**Consultation Response from KC,
Highways Development Management****2024/92779 land at Providence Street, Earlsheaton, Dewsbury, WF12 8HZ****Outline application for residential development****Date Responded: 19-8-2025.****Responding Officer: Mark Berry.****Responding Ref: 15-6SE-13.**

This is an outline application for residential development at land at Providence Street, Earlsheaton, Dewsbury.

Appendix F Proposed Site Access Arrangements (Optima Drawing No. 24023/GA/01/A)

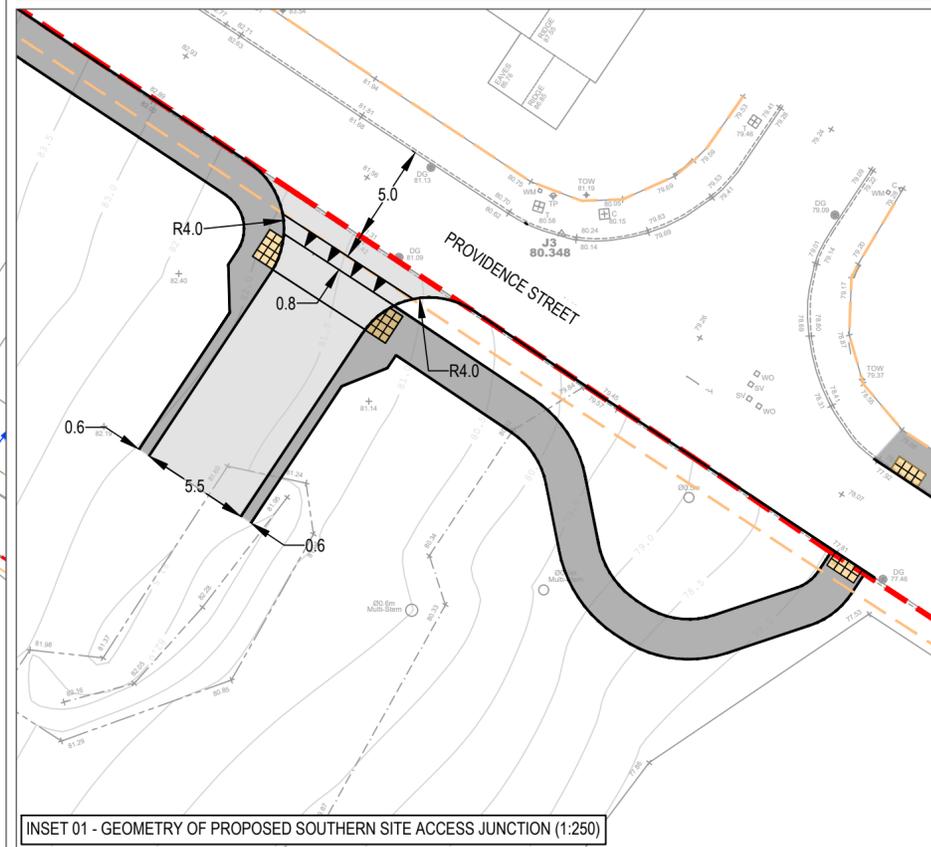
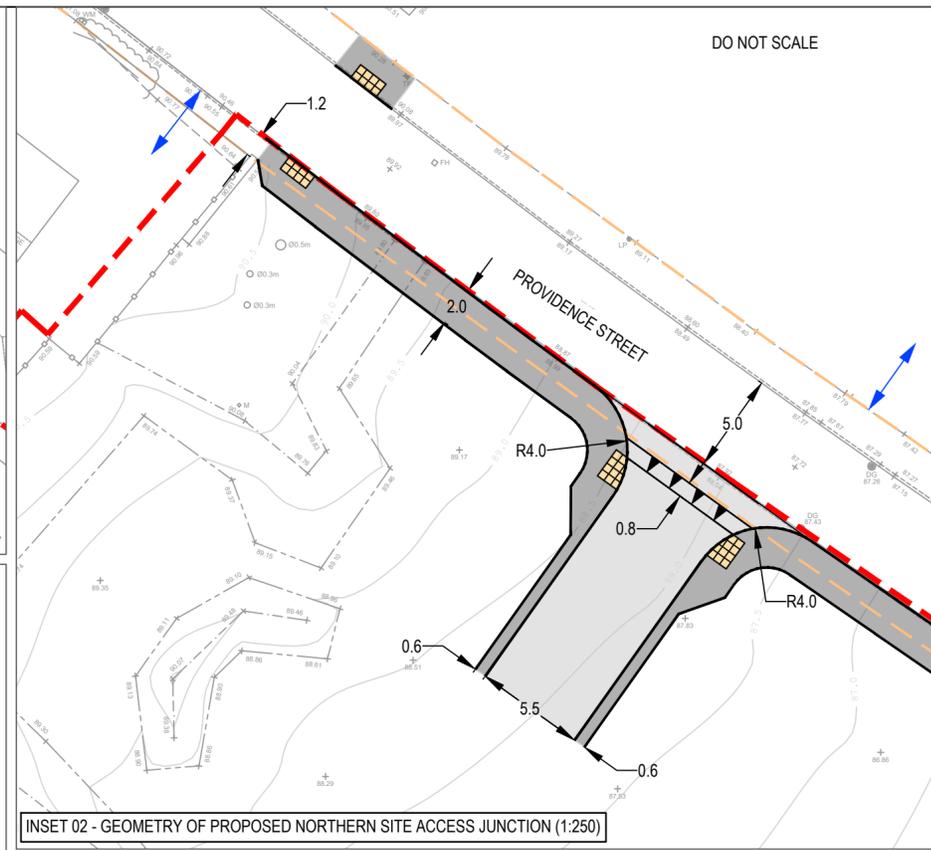
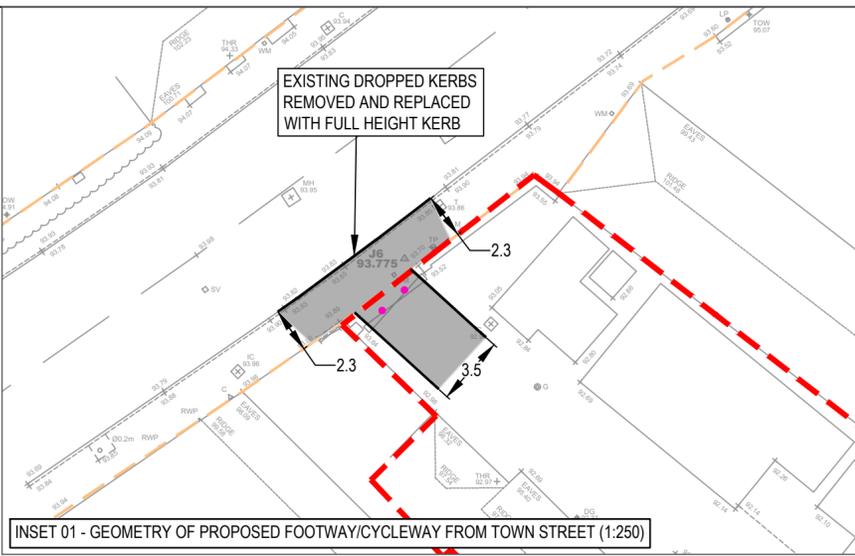
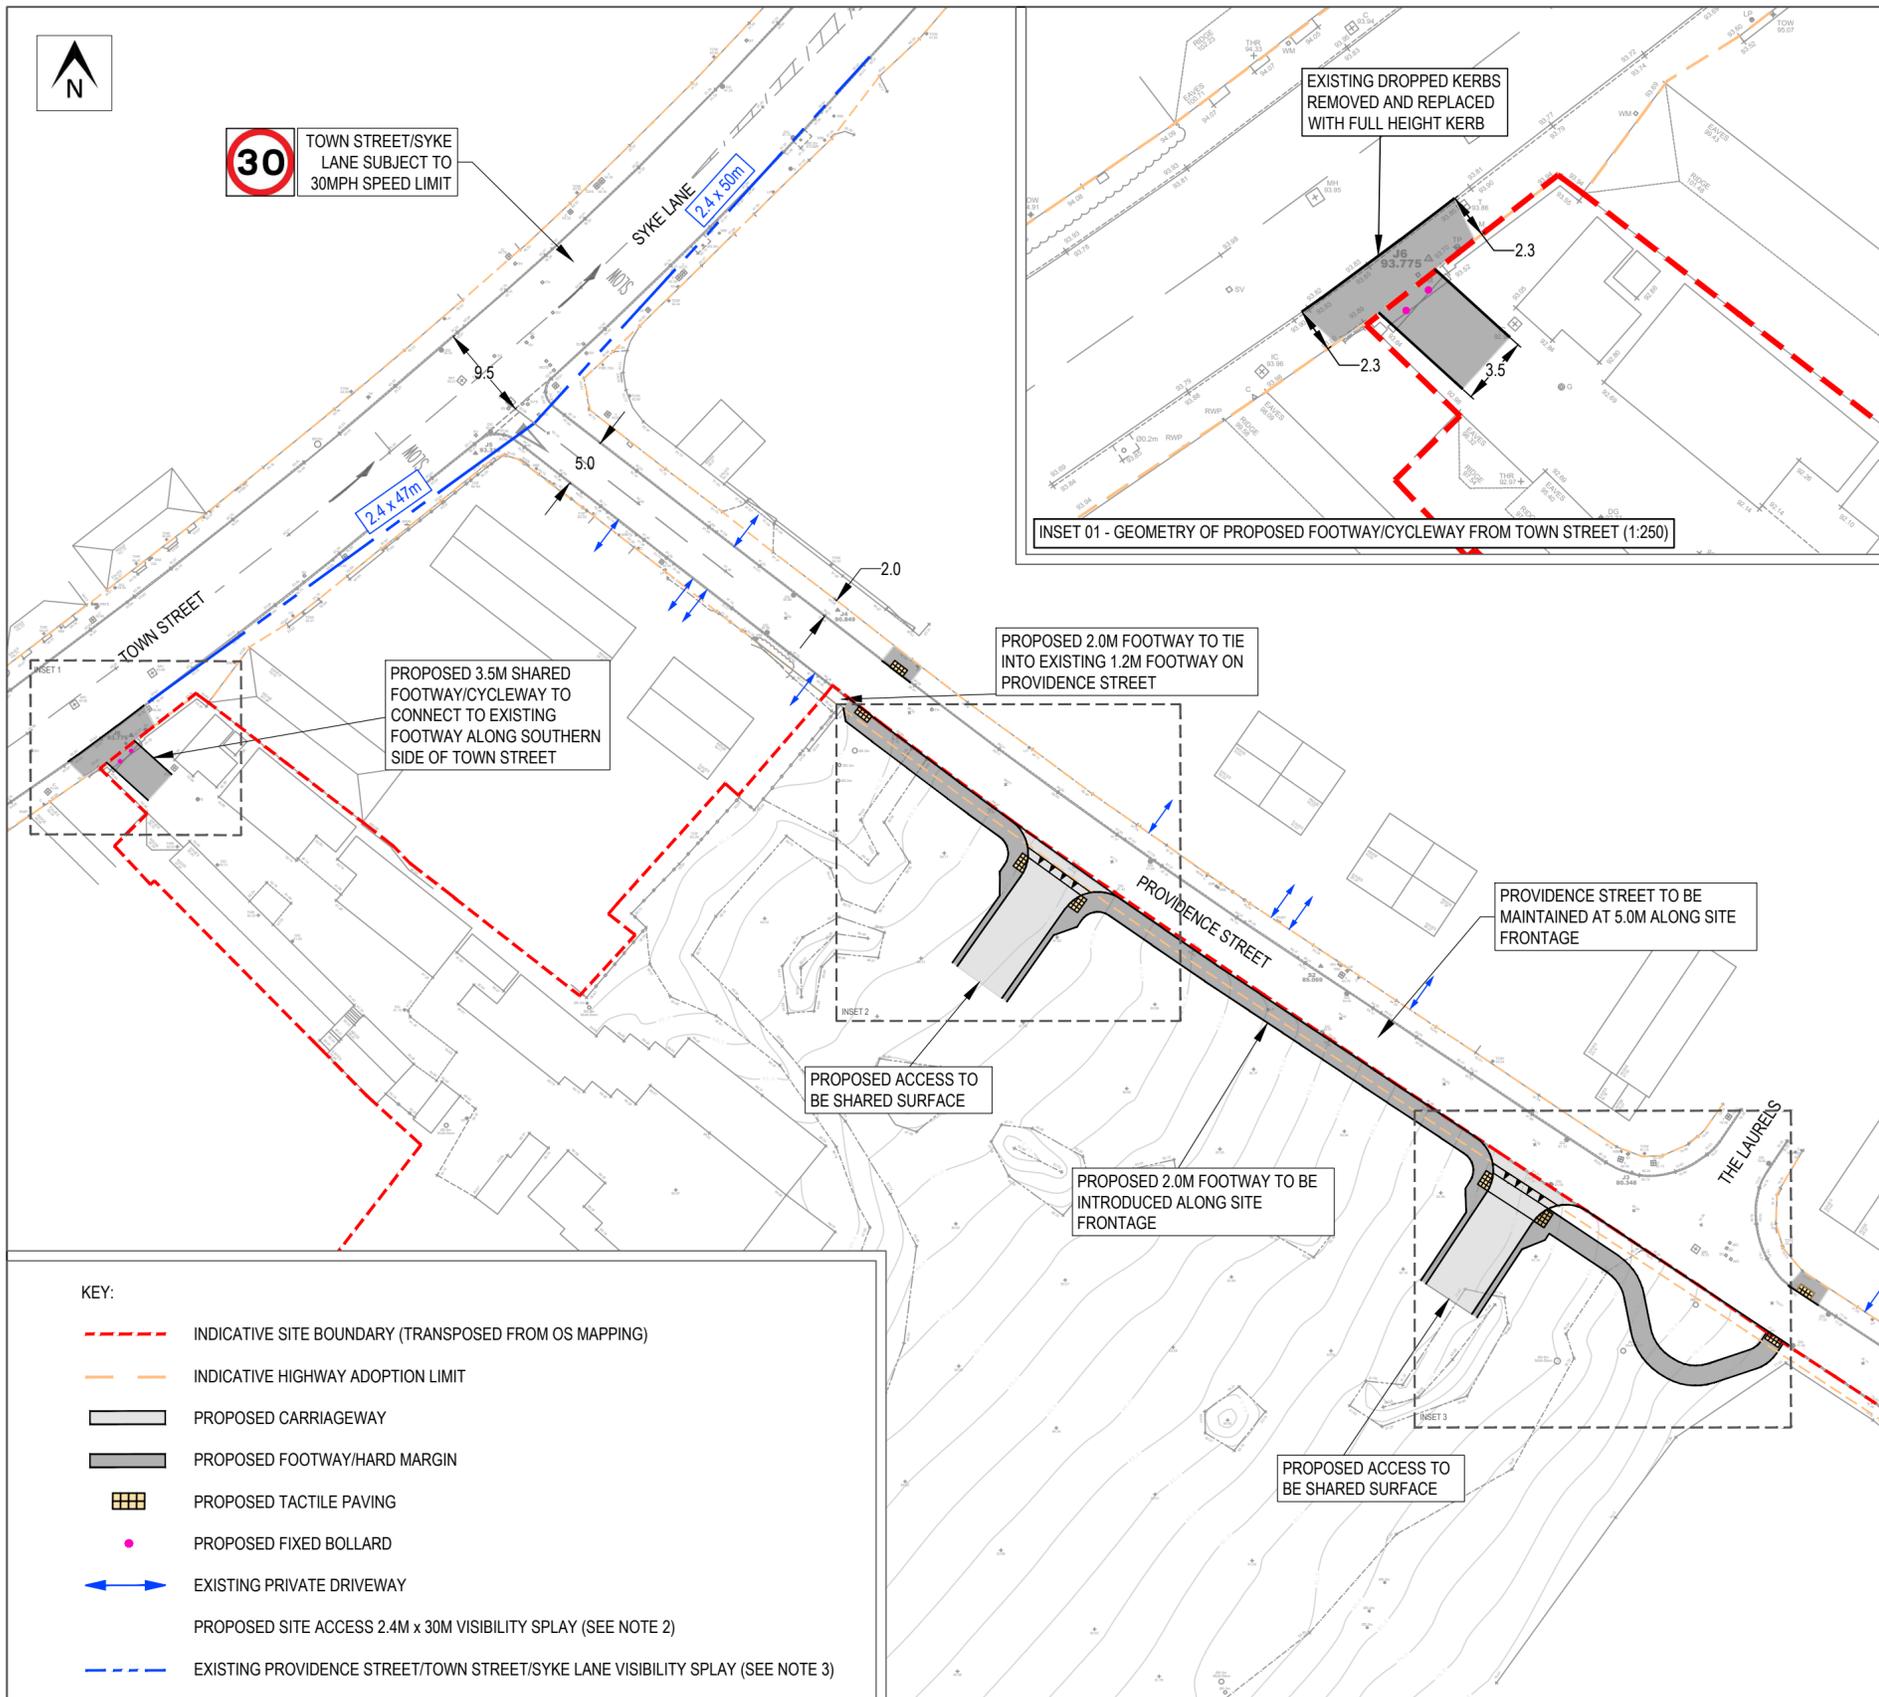
Notwithstanding the details shown on the approved plan, the development shall not commence until a scheme detailing the provision of a 2.0m wide footway to the Providence Street Site Frontage as shown on drawing number 24023/GA 01 rev C and a 3.5 m shared footway/cycleway on to Town Street, construction specification, surfacing, drainage and kerbing including the relocation of an existing street lighting column and associated highway works has been submitted and approved in writing by the Local Planning Authority. The development shall not be brought into use until the approved scheme has been implemented and thereafter retained throughout the lifetime of the development.
